AQUIND INTERCONNECTOR

Environmental Statement – Volume 3 – Appendix 19.1 Consultation Responses

Document Ref : 6.3.19.1

DATE: 14 NOVEMBER 2019

Plate 2 – Karst Features (Karst features shown in pale red circles)

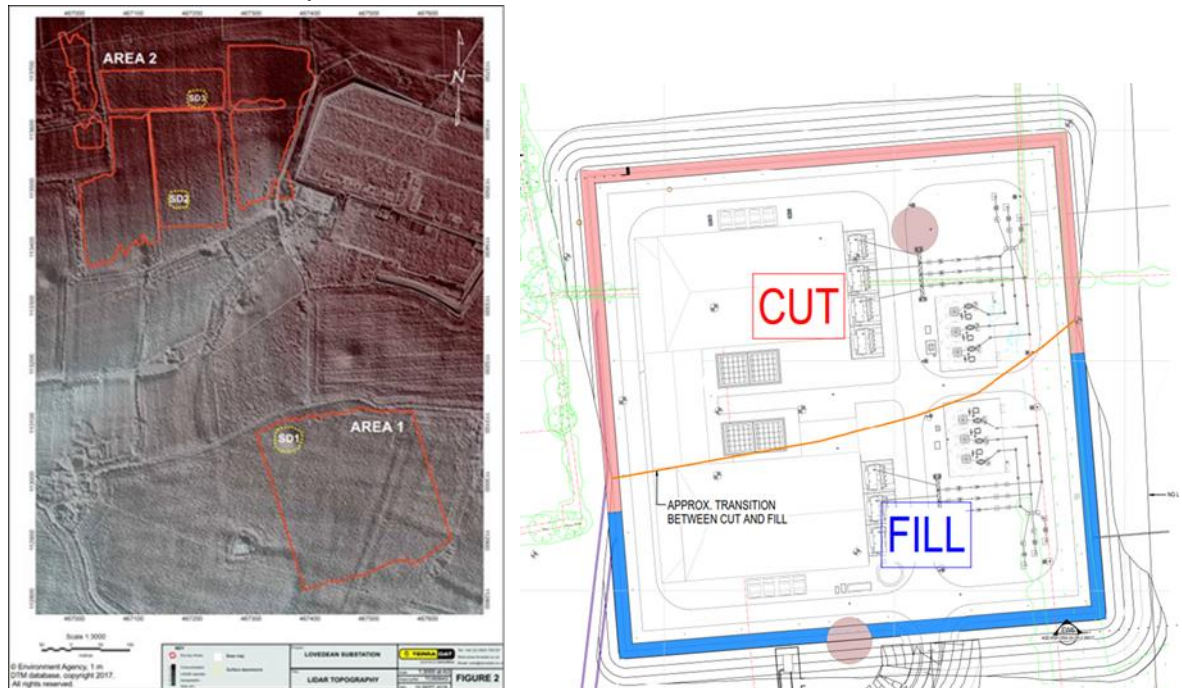
Consultee	Summary of Comment Received	How this has been Addressed by the Applicant
Environment Agency ('EA')	Further consideration is required of the impact of the development in relation to the Karst features and locations within the Source Protection Zone 1	<p>Groundwater team has conducted a site visit and the embedded mitigations include for grouting of the two karsts features located within the Converter Station footprint.</p> <p>No other karst features are known to be present within the remaining Onshore Cable Corridor.</p>
EA	Detail regarding pollution prevention measures during construction and operation need to be provided to ensure robust protection of groundwater	This has been addressed in Chapter 19 (Groundwater) of the ES (document reference 6.1).
EA	<p>Area to the North part of Section 2 and South part of section 3.</p> <p>This area will have high groundwater levels. Dewatering maybe required for any excavation, particularly at a time of high groundwater. Significant groundwater flows may occur. We would advise specialist hydrogeological assessment of potential requirements in this area, particularly for the installation/construction phase of the development.</p>	<p>Preliminary design shows the Proposed Development (with the exception of HDD-5) will be built within 1.5 m of surface during late summer and early autumn when groundwater levels are low. Groundwater levels will therefore be below the proposed installation depth removing the need for a specialist hydrogeological assessment.</p> <p>Addressed qualitatively in Chapter 19 (Groundwater) of the ES (document reference 6.1).</p>

**Compulsory Aquisition Hearing 1 – Appendix 1
- Exhibit 8 Plan showing location of karstic or
other surface water features**

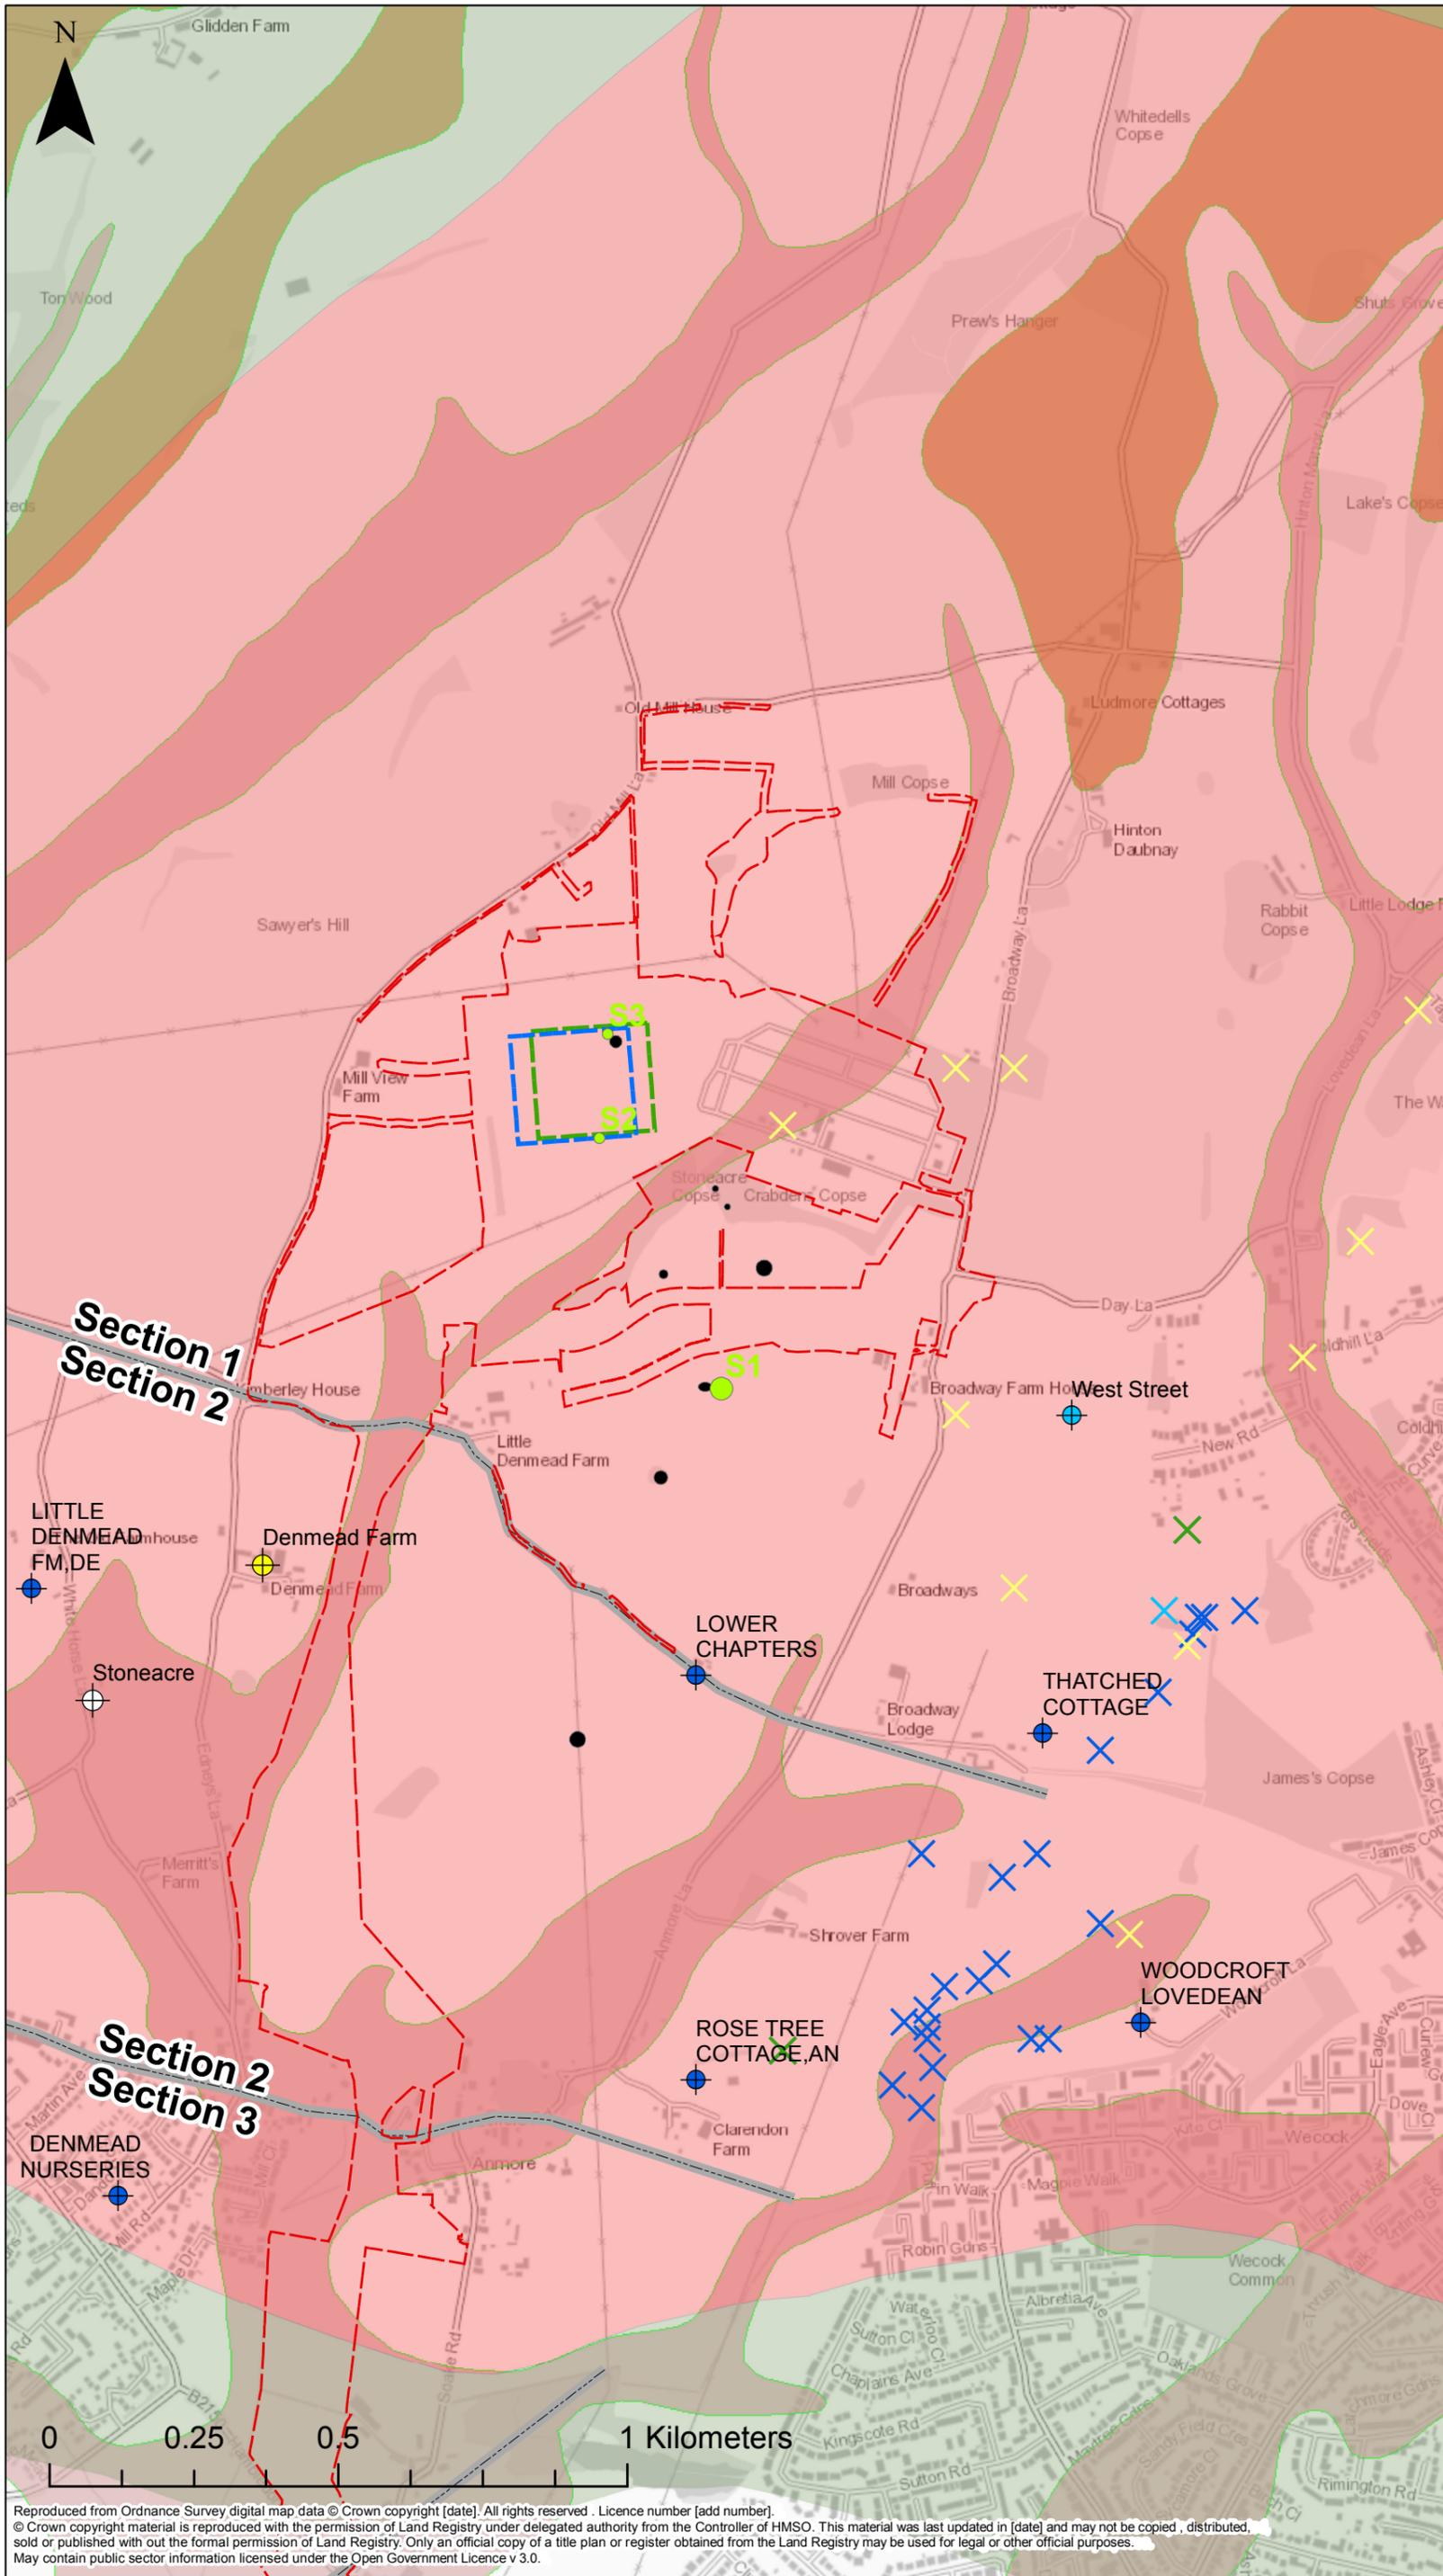
- The EA and Portsmouth Water would like an understanding of the Chalk Karst network developing in the design stage of works.
 - PCC raised issues regarding groundwater flooding.
